EPA Request for more Information on Environmental Impacts

Thank you for the request for advice from Public Authority Consultation (PAE-32670512), requesting the review by the NSW Environment Protection Authority (EPA) of the Environmental Impact Assessments for the proposed Second Thermal Oxidiser (Application DA246/96 MOD-4) at Terminals P/L, 45 and 51 Friendship Road, Port Botany (the premises).

Attachment A – EPA review of the AQIA for Mod-4

Attachment B – EPA review of the WMIA for Mod-4

F2

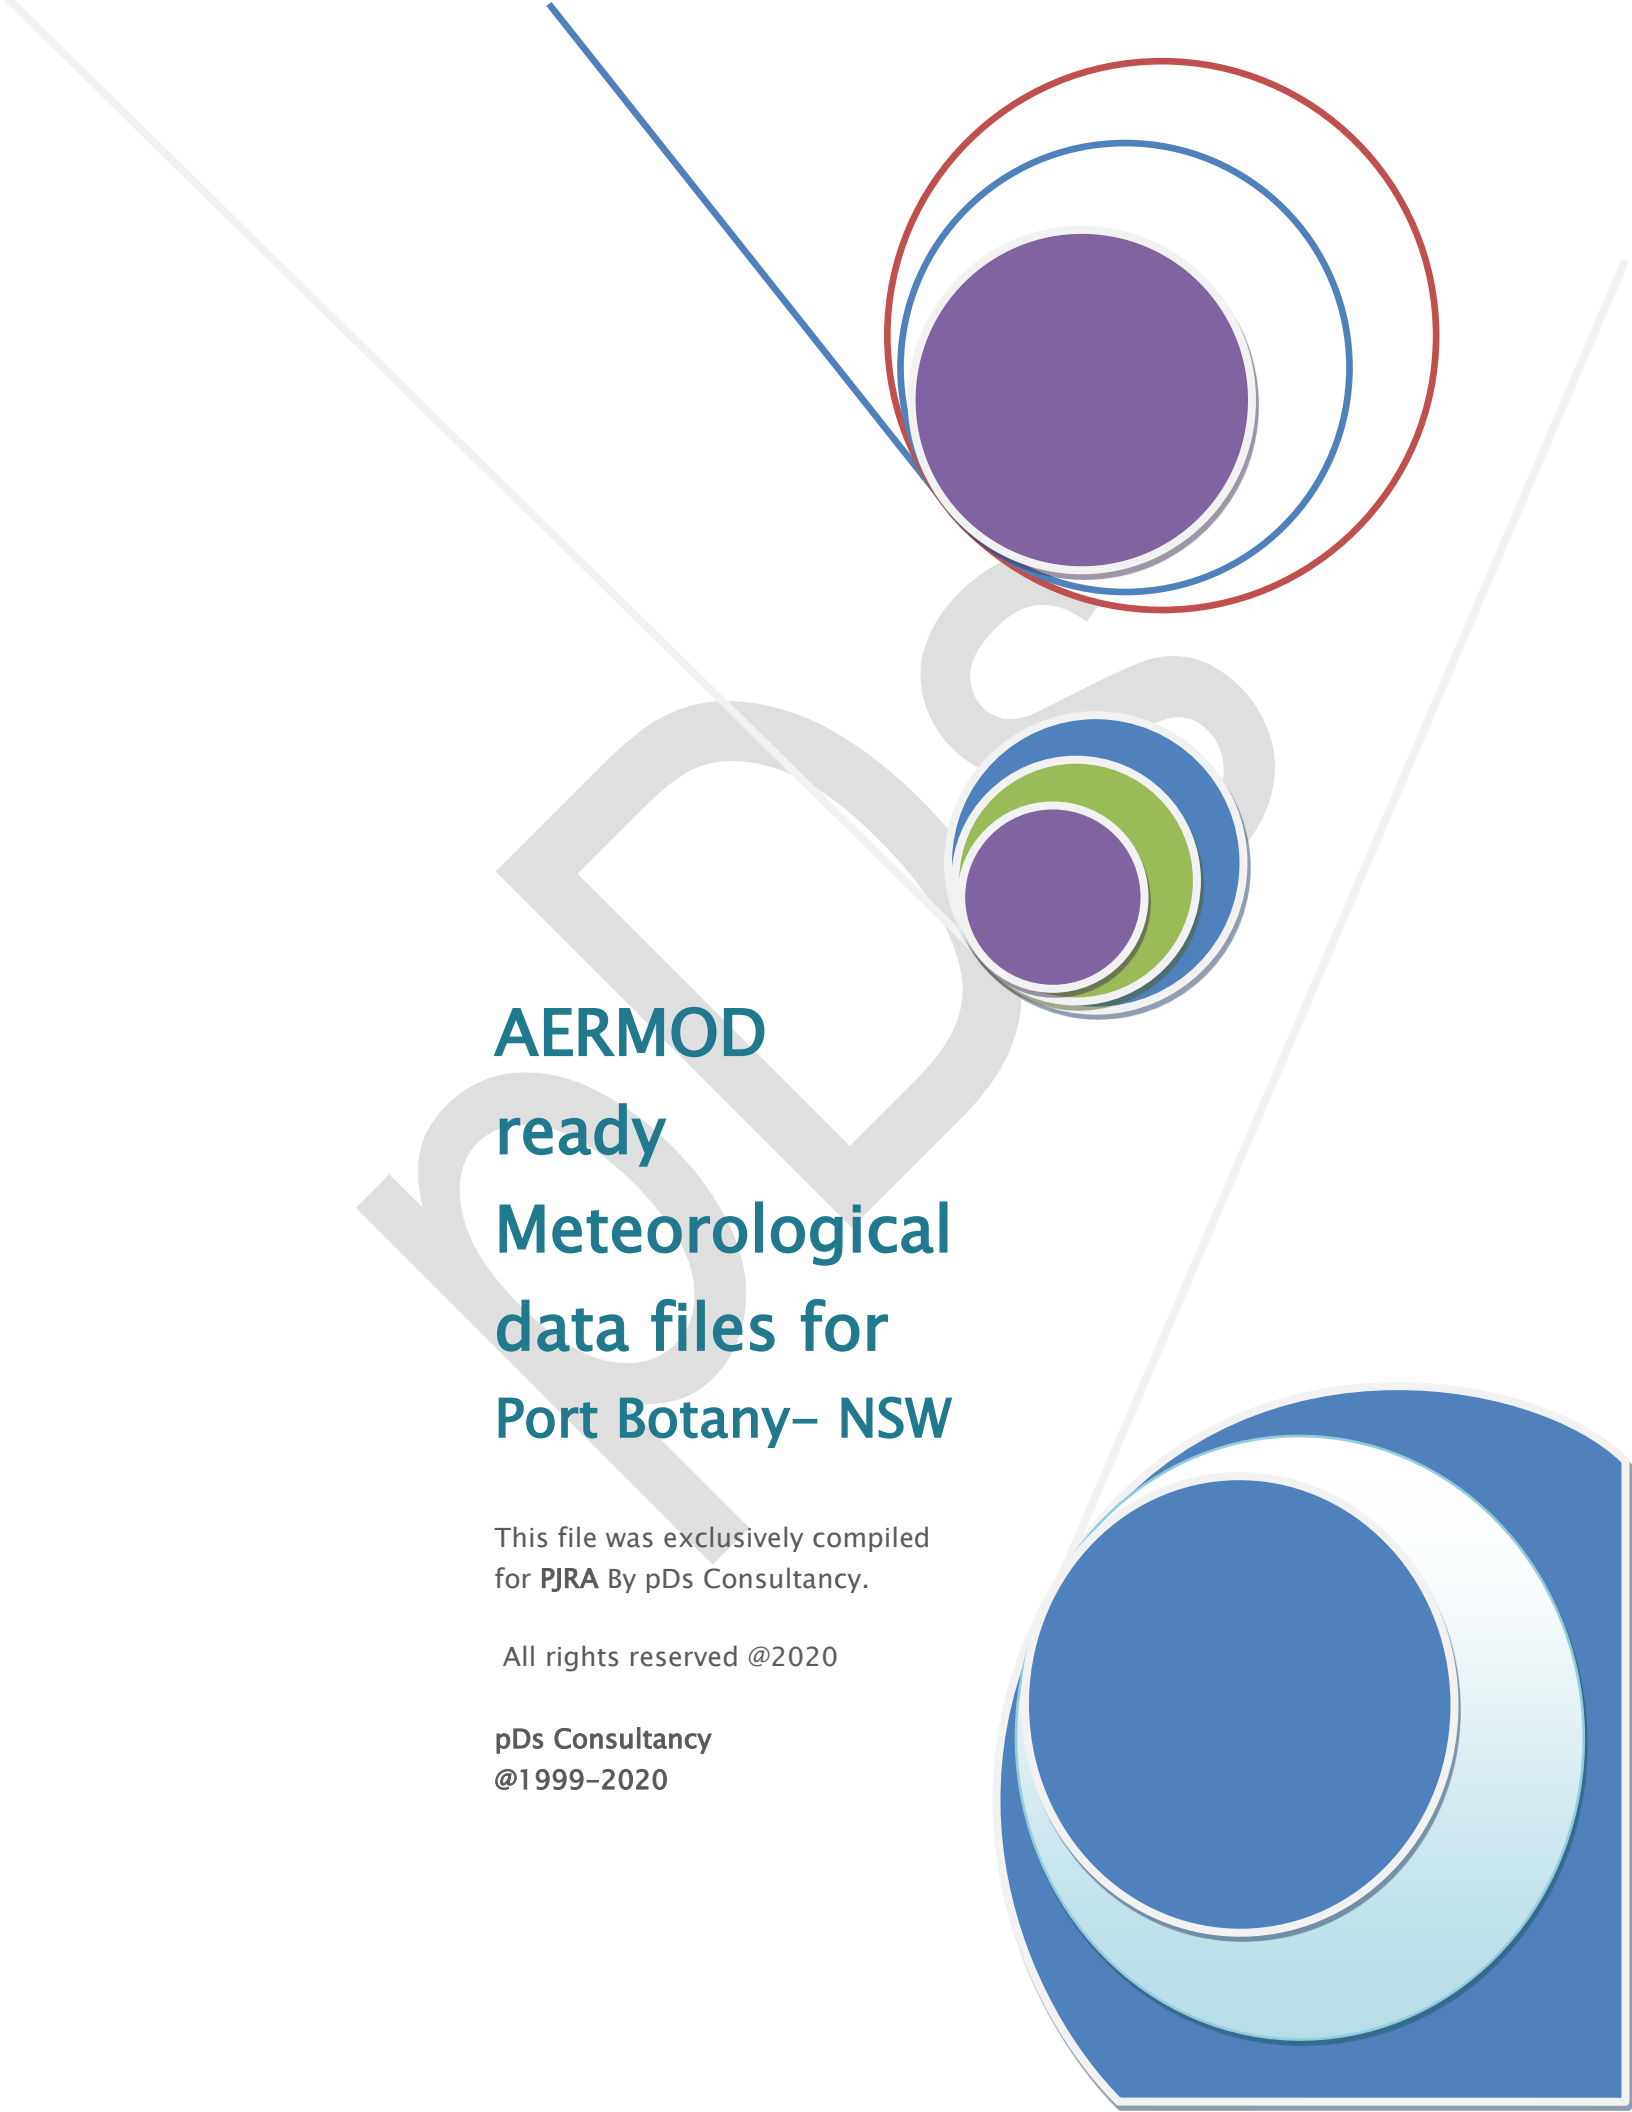
Despite all these inconsistent and unclear emission concentration, parameters and emission rates, the predicted impacts (Tables 9, 10, 11 and 12, Figures F3, F4, F5 and F6) remain exactly the same as presented in the revised AQIA for Mod3. Figure F3 of the predicted impacts remain dated 10/2/2021 which indicates the model has not been updated to reflect changes made as outlined above.

The EPA recommends that the proponent either confirm that the predicted impacts remain valid or remodel them using the correct and updated emission parameters. This should include modelling existing sources at licence limits, clearly outlining the expected emissions performance of the proposed thermal oxidiser in the main AQIA and correcting inconsistent or incorrect emission parameters.
